CITY OF ALBUQUERQUE

June 1, 2017

RE: American Toyota-Phase 2
5995 Alameda NE
Requested for 180 Day Temporary C. O. - Accepted
Engineers Stamp Date 7/22/15 (C18D012)
Certification dated: 5-26-17

DAVID SOULE P.E. #14522	AMERICAN TOYOTA		DRAWN BY WCWJ
	GRADING AND DRAINAGE PLAN		DATE 7-22-15
	 Rio Grande Engineering 1806 CENTRAL AVENUE SE SUITE 201 ALBUQUERQUE, NM 87106 (505) 872-0999		21403-LAYOUT-1-25-14
			SHEET # — JOB # 21403

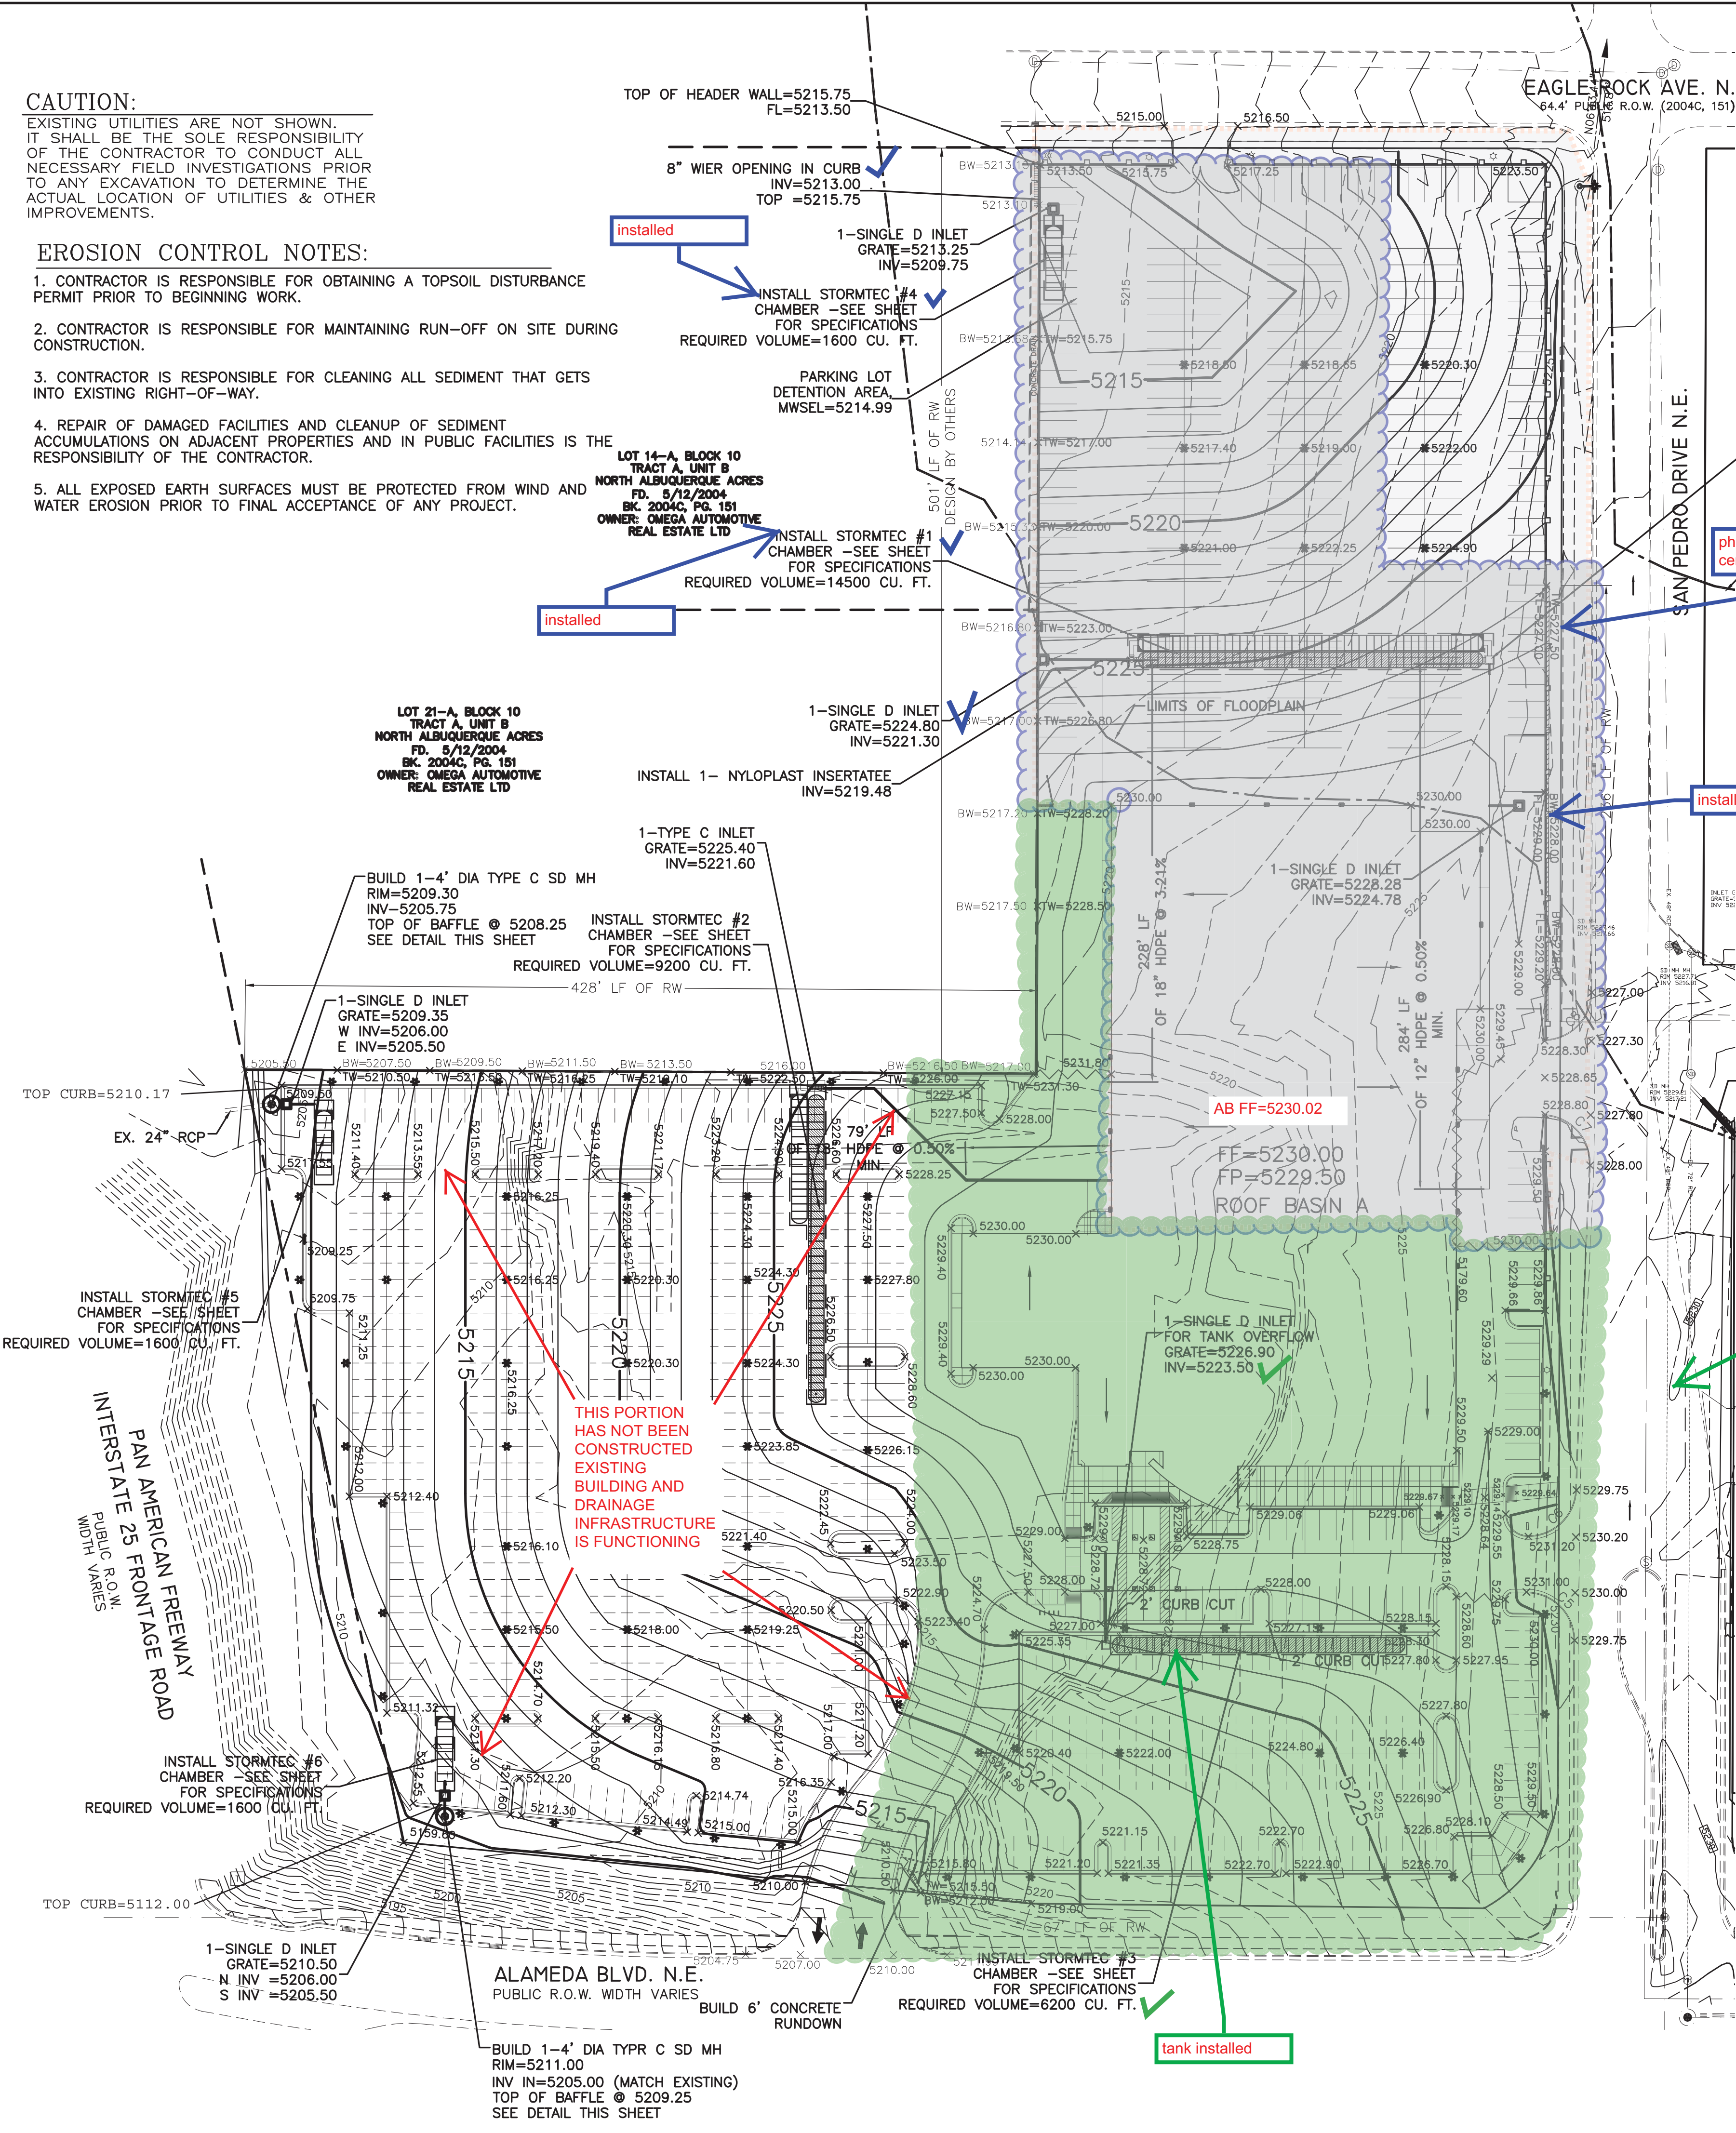
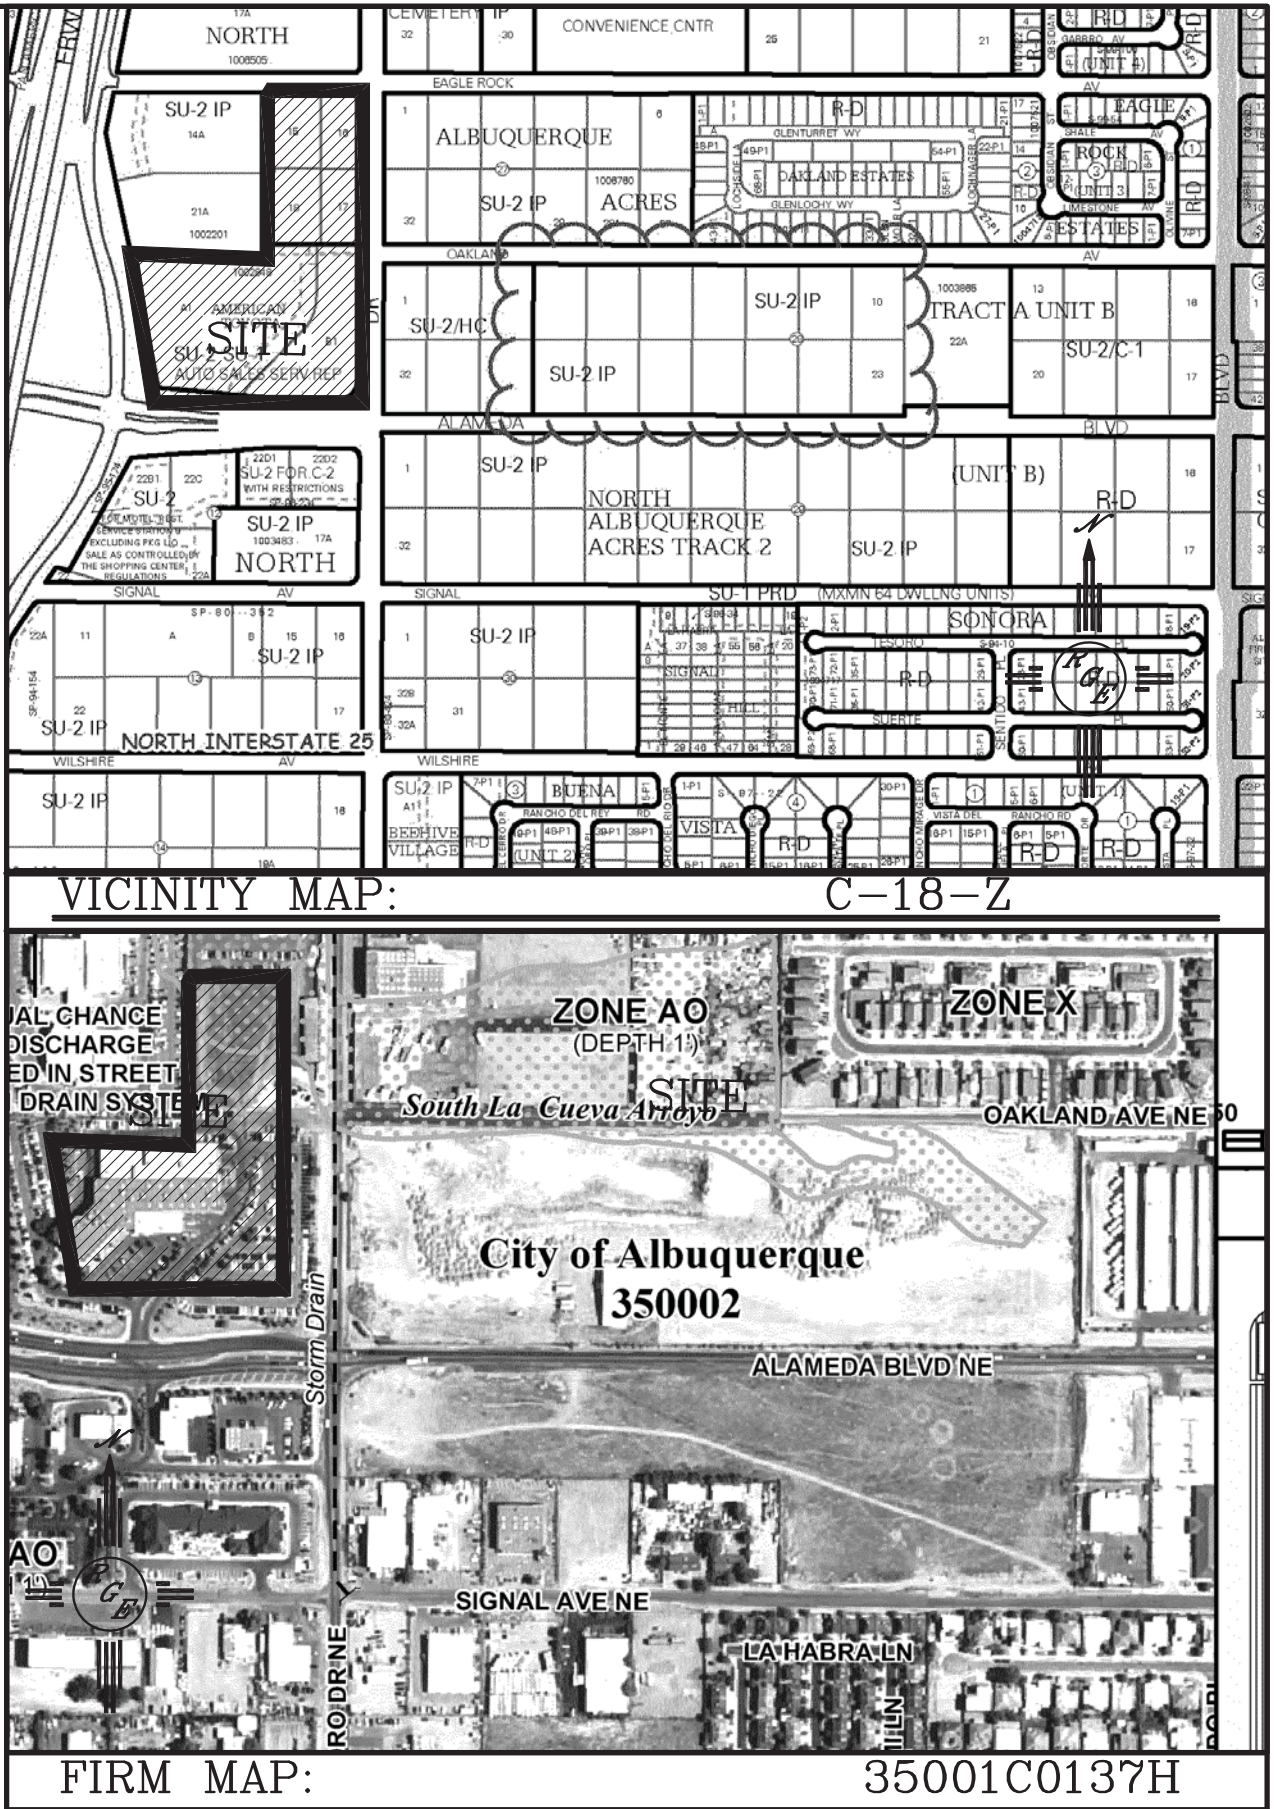
- Clarify 2 additional inlets in NW corner of parking lot.
- Clarify 1 additional inlet on north side of carwash in middle of chamber.
- Clarify 1 additional inlet on south side of building, west end of chamber.
- Clarify 1 additional inlet in SW corner of parking lot.
- Call out curb cuts on southern end of parking lot along Alameda.
- Call out sidewalk and sidewalk culvert on as-built.
- Cut plate on SW culvert flush with sidewalk.
- Paint plate on SW culvert grate with 1 shop coat red oxide, 2 finish coats of aluminum paint (AASHTO M 69).
- Provide safety railing at vertical drop at SW corner of parking lot next to main entrance on Alameda.

All corrections must be as-built on permanent CO submittal. An inspection by our office will need to take place after these corrections are made.
